A1 Birtley to Coal House

Scheme Number: TR010031

Statement of Common Ground with Gateshead Council

**STATEMENT OF COMMON GROUND
WITH GATESHEAD COUNCIL**

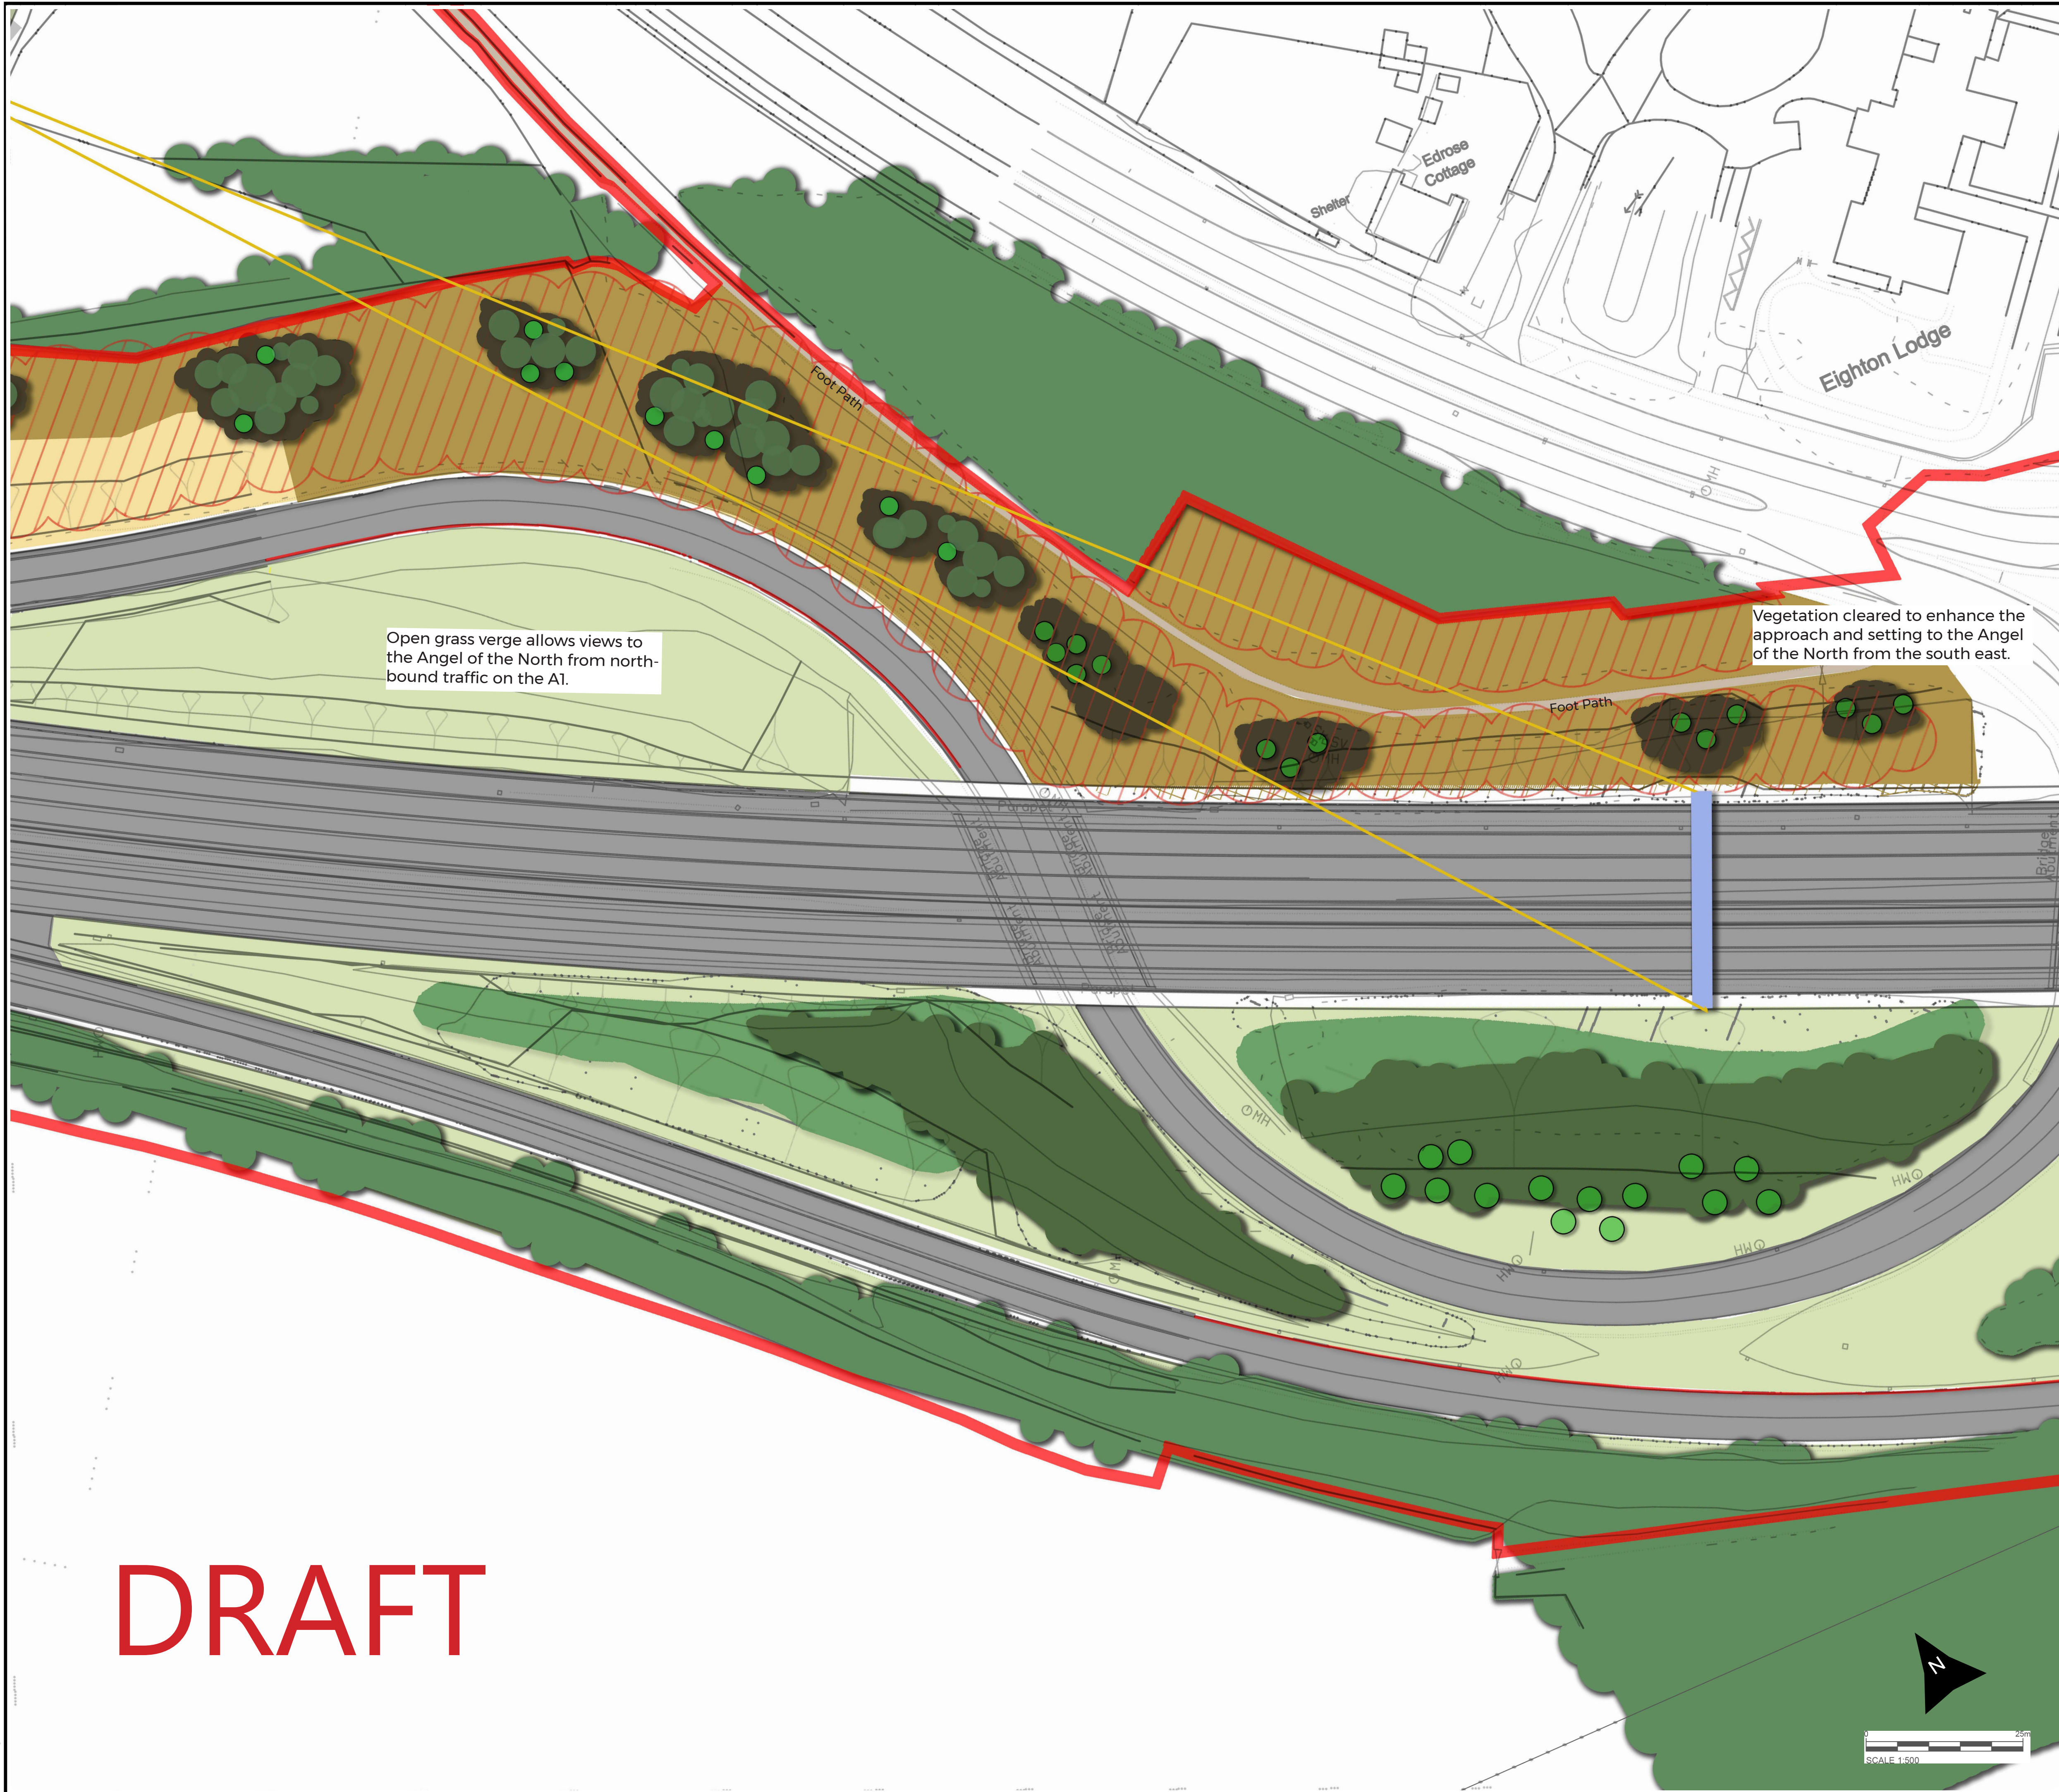
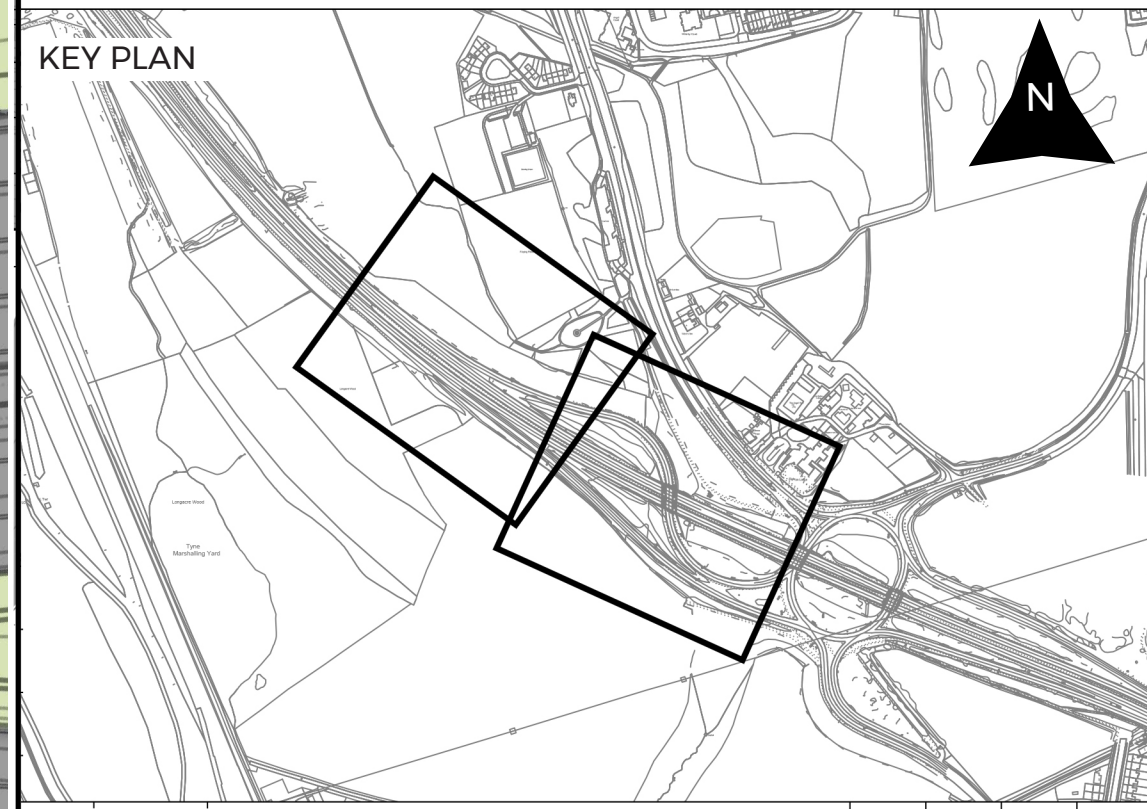
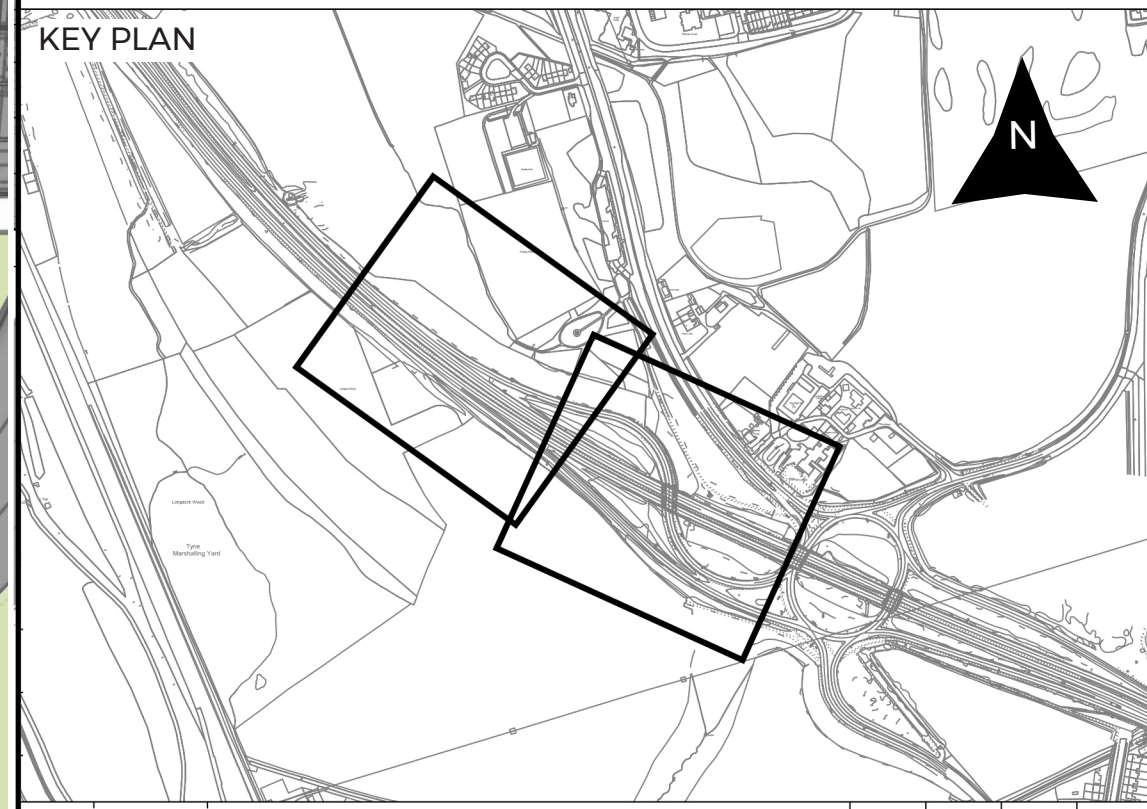
Section	Sub-section	Gateshead Council Position	Highways England Position	Status
Environmental Statement - Chapter 6: Cultural Heritage	6.8 Potential impacts	<p>At a meeting on Thursday 4 June 2020, Gateshead Council advised that they find the revised landscape mitigation plan around the Angel of the North [REP5-005] broadly acceptable, <u>and this was confirmed in an email on the 8/6/20.</u></p> <p><u>At a subsequent meeting on the 3/7/20, Gateshead Council confirmed that their position remains that the preferred option from the Southern Green Report [REP4-086] is Option 3 – Revealing the Angel, however, and that they were are happy to continue discussions, -with the Applicant outside of the examination period, in order to deliver this through into the detailed design stage.</u></p>	<p><u>Following a meeting on the 3/7/20, it was confirmed that the landscape strategy, as set out in Figure 7.6: Landscape Mitigation Design [APP-061] would remain the current design, any changes that are agreed following further, without prejudice discussions, would be undertaken during the detailed design phase, and be subject to agreement with Gateshead Council. Any changes to the design will ensure that the impact assessment detailed within Chapter 8: Biodiversity of the ES [APP-029] and Chapter 7: Landscape and visual of the ES [APP-028] will remain valid.</u></p>	<p>Under-Discussion <u>Agreed</u></p>

<p>Gateshead Council recognises tensions between artist, climate change and ecology views. Gateshead Council requested visuals of the proposed A1 works showing the landscape in its finished (post construction) massing would assist in developing the</p>	<p><u>During a meeting in the 3/7/20 it was agreed that until such time as there is further discussions and agreement on the proposed changes associated with the Angel of the North location, the current landscape design, set out in Figure 7.6: Landscape Mitigation Design</u></p>	<p>Under-Discussion <u>Agreed</u></p>

Section	Sub-section	Gateshead Council Position	Highways England Position	Status
		<p>[REP5-005], the Council did not agree that there will permanent beneficial impacts on the setting of the Angel as a result of reduced planting, and the effect of the gantries will be significant Gateshead Council has advised that their concerns on this matter have been reduced and the principles set out in the landscape mitigation scheme have been agreed.</p>	<p>restricted due to the installation of gantries but the effect would not be significant. Appendix 2.0 B Gantry Report [EX/D4/015] of the Applicant's Response to the ExA's Second Written Questions addresses the effect that these gantries will have on views of the Angel of the North and confirms that the effect of the installation of the gantries on the Angel of the North would not be significant.</p>	
		<p>The appearance of the new underpass is agreed by Gateshead Council.</p>	<p>Noted and agreed</p>	<p>Agreed</p>

Section	Sub-section	Gateshead Council Position	Highways England Position	Status
		<p>detailed landscape design and enable views to be managed alongside gantries and other infrastructure.</p> <p>Agreed in November 2019 that a single joint landscaping scheme should be developed by Highways England and Gateshead Council. Discussions are ongoing.</p> <p><u>At a meeting on the 3/7/20, Gateshead Council confirmed that their position remains that the preferred option from the Southern Green Report [REP4-086] is Option 3 – Revealing the Angel, and that they were happy to continue discussions with the Applicant in order to deliver this through into the detailed design stage. However, until such time the current landscape design, set out in Figure 7.6: Landscape Mitigation Design [APP-061] remains the current design agreed within the DCO examination.</u></p>	<p><u>[APP-061] remains the current design agreed within the DCO examination.</u></p> <p><u>During the meeting a number of points were discussed on how the design could be taken forward and the constraints and opportunities that may influence the final design, not least that there should be not additional financial cost to the Applicant in delivering the aspirations of Gateshead Council, and these are outline below.</u></p> <p><u>It is confirmed that the Gateshead Council and the Applicant continue to make progress on their discussions on how the Scheme could support the aspirations of the Council in making changes to the landscape around the Angel of the North, in removing some of the established trees and shrubs and increasing visibility of the Angel of the North within views from the A1.</u></p>
